Submission on the Stage 2 EIS for the Northern Beaches Hospital (SSI 6792)

Stage 2 Environmental Impact Statement State Significant Infrastructure (SSI 6792) Northern Beaches Hospital

This document is Warringah Council's submission in response to the exhibition of the Stage 2 - Environmental Impact Statement (EIS) for the State Significant Infrastructure (SSI) application (SSI 6792) for the proposed Northern Beaches Hospital at Frenchs Forest

Figure 8-18 Traffic Flow Diagram Plan for Pedestrians to Access the Bus Stop

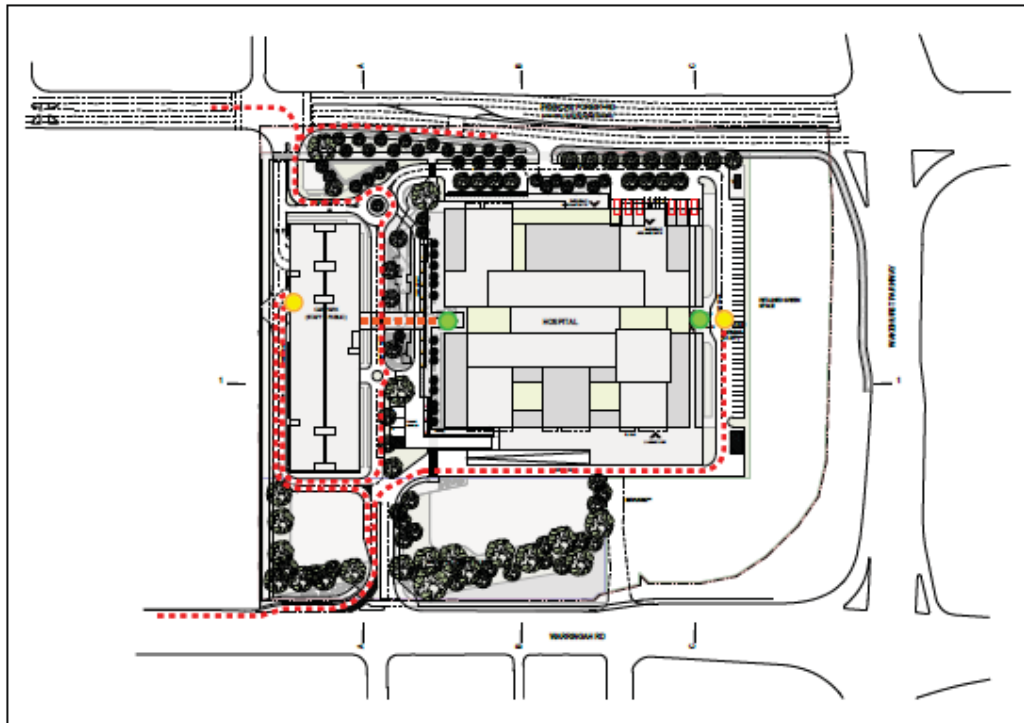
Page 35, paragraph 3, mentions access for pedestrians to bus stops – Figure 8-18 shows pedestrian access through the site, but fails to mention pedestrian thoroughfare along the western boundary. These routes should be well lit to ensure safety of pedestrians
